**Pre-application
enquiry reference
Proposal**

PA20/02119/PREAPP

Pre application advice for the conversion of a barn to a dwelling.

Trekennick House Altarnun Launceston Cornwall
Mr S Walker And Ms C Templeton-Walker

GROUND FLOOR PLAN

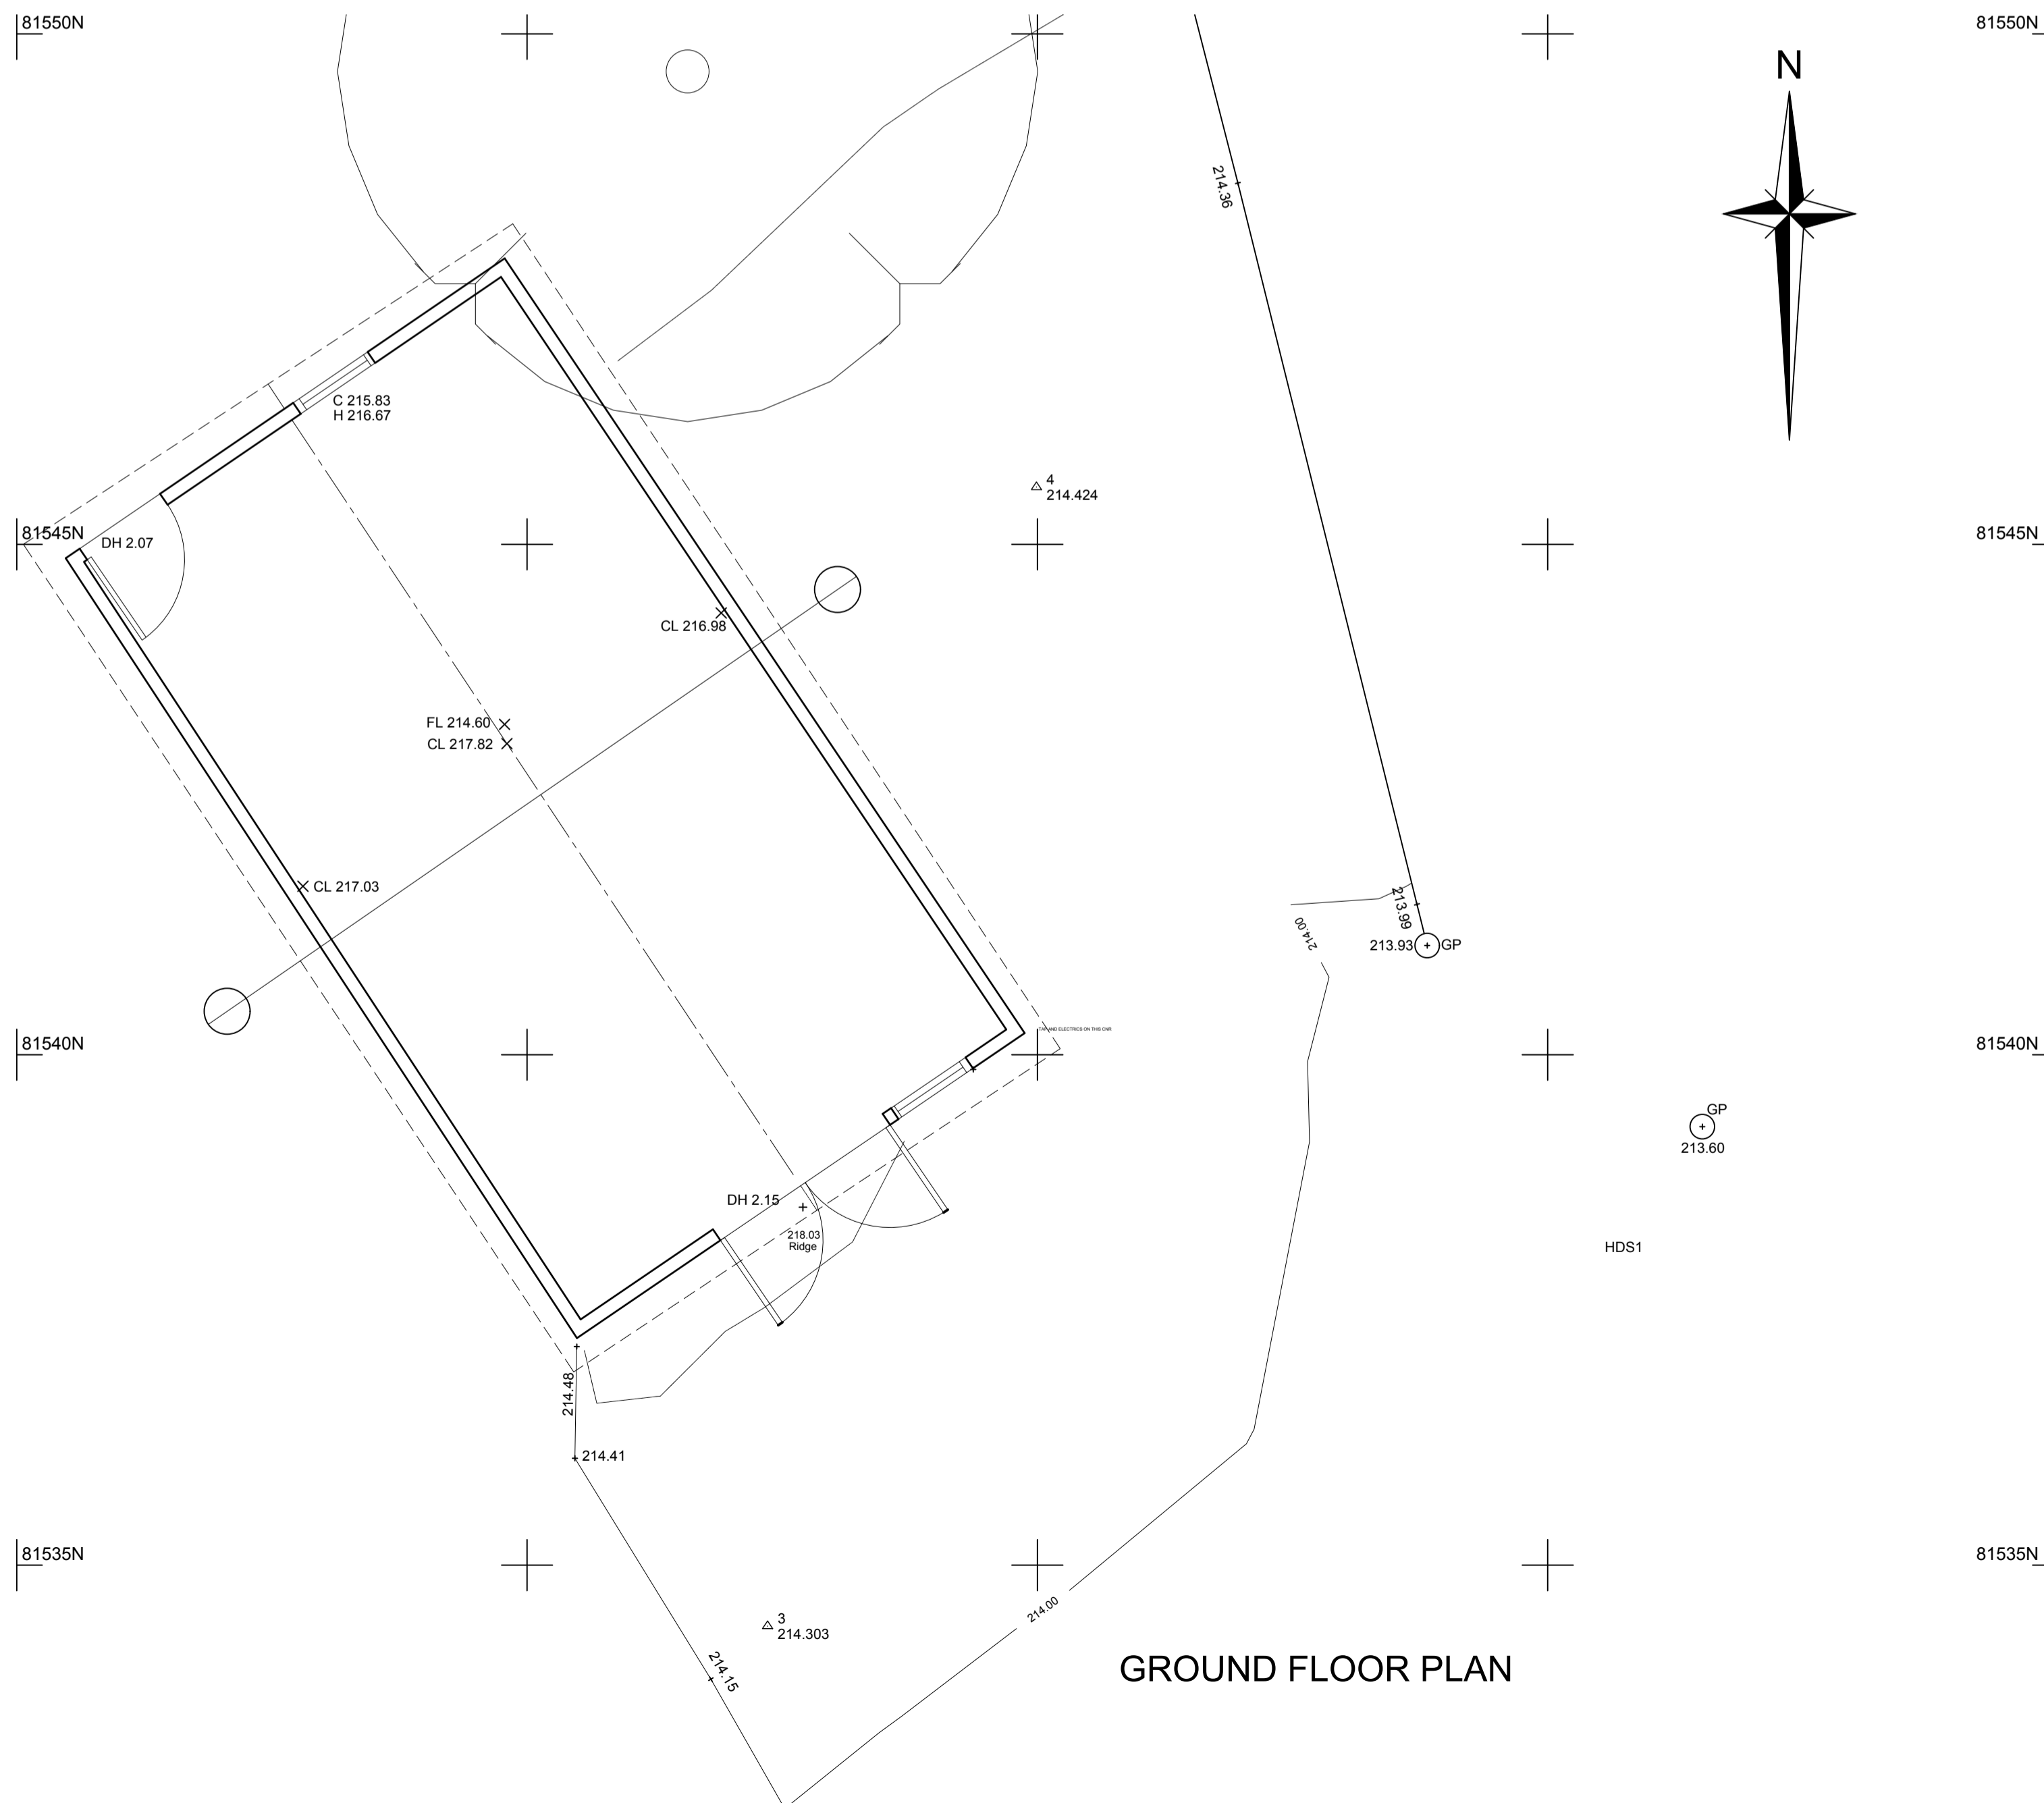
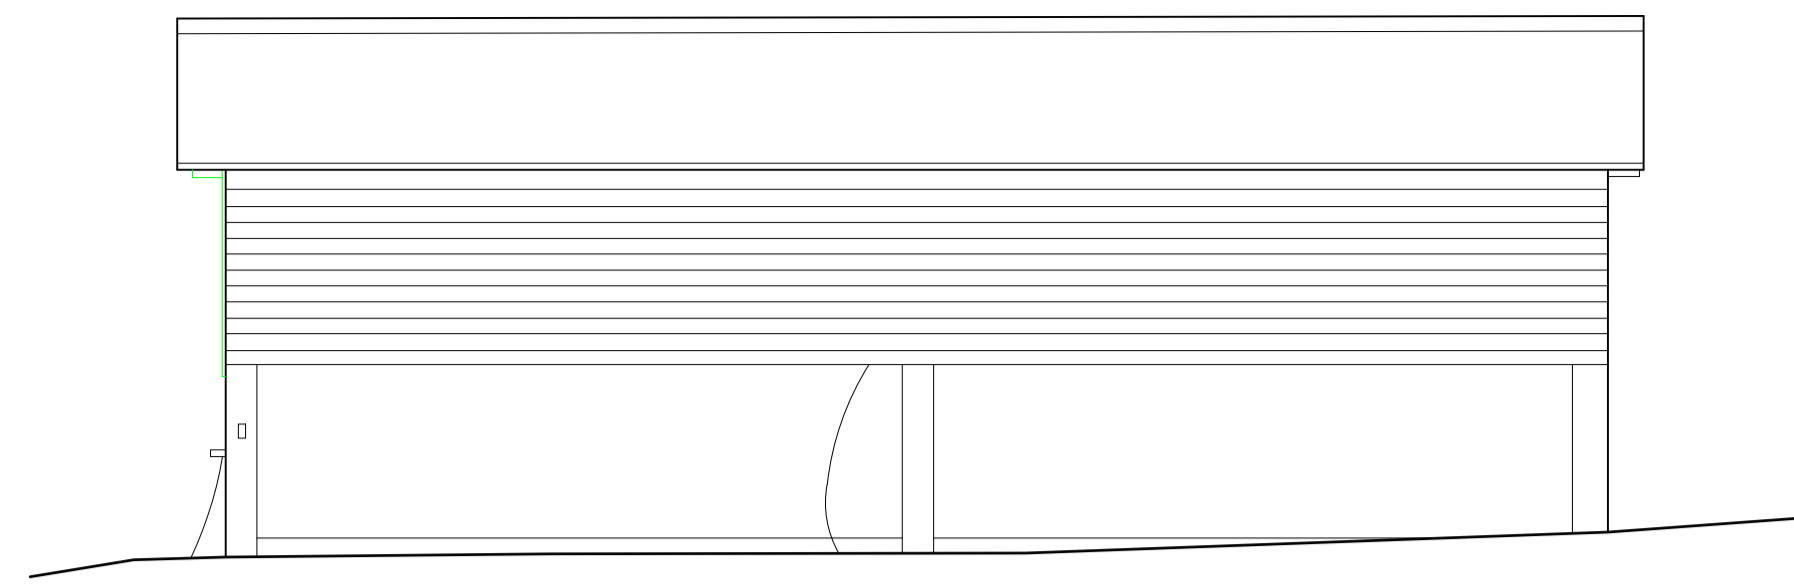
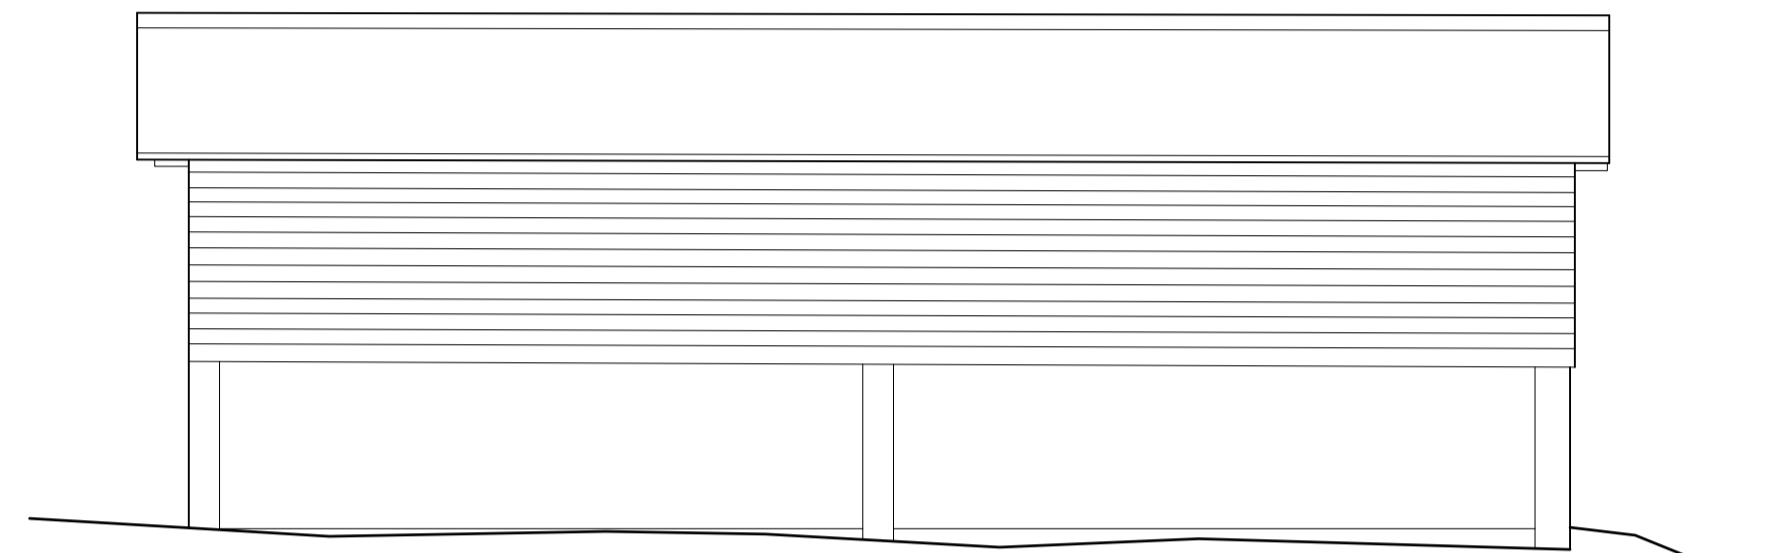
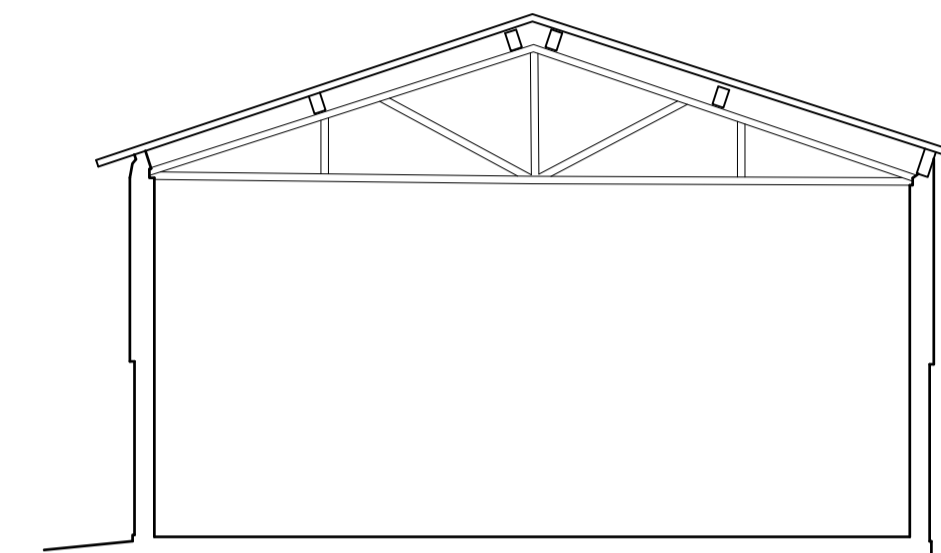
The storage building in question is a simple, block and timber clad structure with lightweight roof that appears to have been used historically for overspill storage purposes. It is approximately 45 sqm in area and is located some 30m from the main dwelling outside the immediate curtilage of the main dwelling.

There is no structural report or conversion method statement to comment on, and it is noted that the same applicant sought advice on the demolition and re-building of a larger unit of accommodation here in 2019, which does seem to indicate an initial preference to start again. It is not known for example whether the existing building is structurally strong enough to take the loading required to make it habitable, or whether a slate roof could be introduced.

Its form and appearance is of no historic or architectural merit and there would be no loss to the character and appearance of the immediate area if it were to be removed all together. It is also only 45sqm in area, which is below Nationally Prescribed Space Standards for a double bed single storey property (50sqm).

If considering an application, it would be expected that a structural survey with conversion method statement is included to demonstrate structural soundness.

In summary it is questioned whether this particular building is actually appropriate to retain.
